Phone: 0300 123 6780  
Email: [developeras@lancashire.gov.uk](mailto:developeras@lancashire.gov.uk)  
Your ref: 3/2025/0860  
Our ref: 3/2025/0860/HDC/KW  
Date: 10 November 2025

**Location:** Kemple Down Birdy Brow Chaigley BB7 3LR  
**Proposal:** Proposed replacement dwelling.  
**Grid Ref:** 369446 440780

Lancashire County Council acting as the Local Highway Authority (LHA) does not consider that the application as submitted fully assesses the highway impact of the proposed development and further information is required as set out in this response.

PL.20

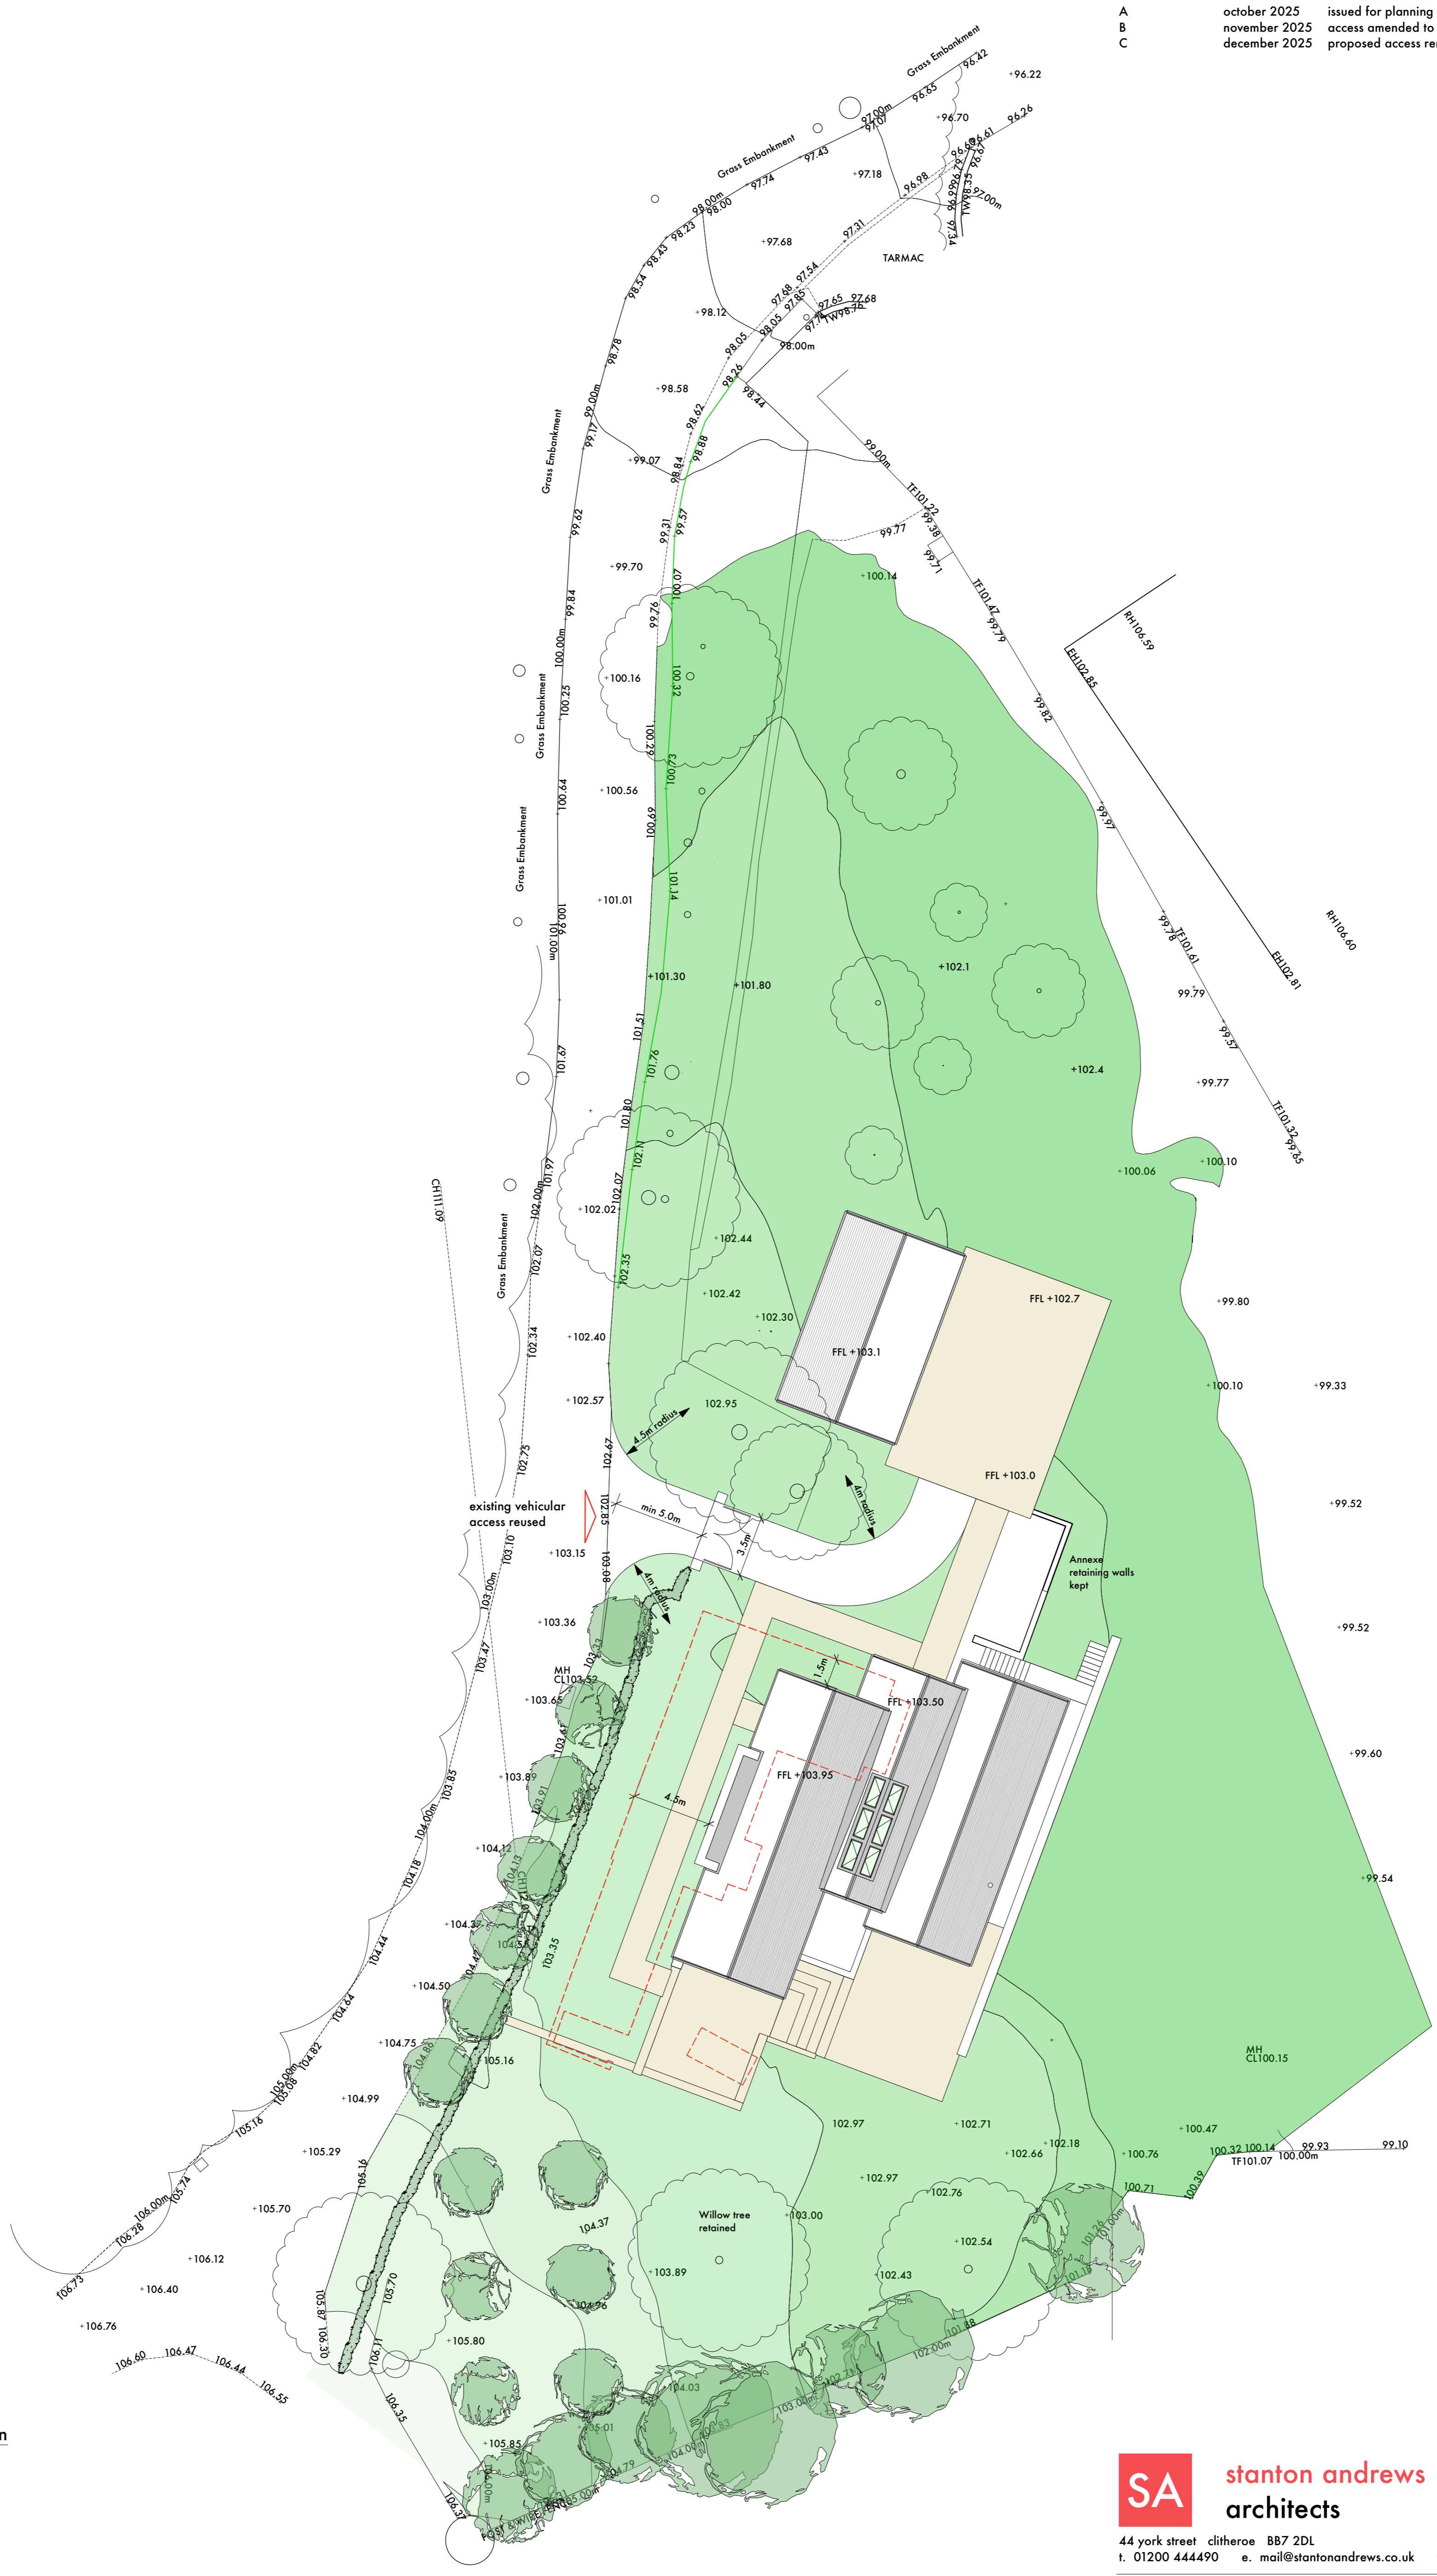
The proposal will result in a new access onto Birdy Brow, which is classified as the C571, with a national speed limit fronting the site access.

The LHA has concerns over the proposed access point due to its positioning near a natural bend in the road, which raises highway safety concerns. The existing access point, which currently sits closest to the bend, is situated approximately 58m from the bend, whereas the proposed access point will be positioned approximately 28m from the bend. The LHA does not support locating access points on or near bends due to highway safety concerns because of limited visibility of those exiting the access and through traffic on the network and the increased potential for conflict.

The proposed access visibility splay also has a significant shortfall in what would be expected for a national speed limit road. Normally, the LHA would look for an access on a national speed limit road to have a visibility splay of 2.4m x 214m. The proposed site plan, Drawing PL.20, shows a visibility splay set 2.4m back for 37 metres to the North and 65 metres to the South of the access. The visibility splay to the North has however, been offset away from the carriageway edge; as such the LHA's view is that the visibility splay to the north is approximately 35.5m without being offset.

The LHA acknowledges that previously a lower visibility splay of 59 metres to the north and 65 metres to the south of the access has been accepted by the LHA, however, the LHA would not support visibility splays that are any lower than the previously approved scheme. The reasons for approving the lower visibility was partly due to the observation of lower speeds than the posted speed limit on Birdy Brow, and that the existing access points has no pre-existing highway safety concerns. The proposed new access point does not hold an existing road safety record and is positioned in a location that causes highway safety concerns.

As such, the LHA cannot support the current proposal and would urge the application to provide an amended plan which provides an access placed further from the bend in the road and has a visibility splay for at least 59 metres to the north and 65 metres to the south.

The LHA have reviewed drawing number PL.20, Rev. A titled Proposed - Site Plan and are aware that the dwelling complies with the LHAs parking standards as defined in the Joint Lancashire Structure Plan. There is also room to turn within the site which will allow ingress and egress in a forward gear.

The recommended minimum internal dimensions for a double garage size is 6m in length and 6m wide. The recommended distance of 6m is based on the length of a large family car (Ford Mondeo Estate 4.58m long), clearance at the rear of the car (200mm), overhang of the garage door (600mm) and room to stand in front of the car and open/close the garage door (600mm). The proposed garage meets the recommended internal dimensions and as such is considered acceptable to provide 2 off street parking spaces.
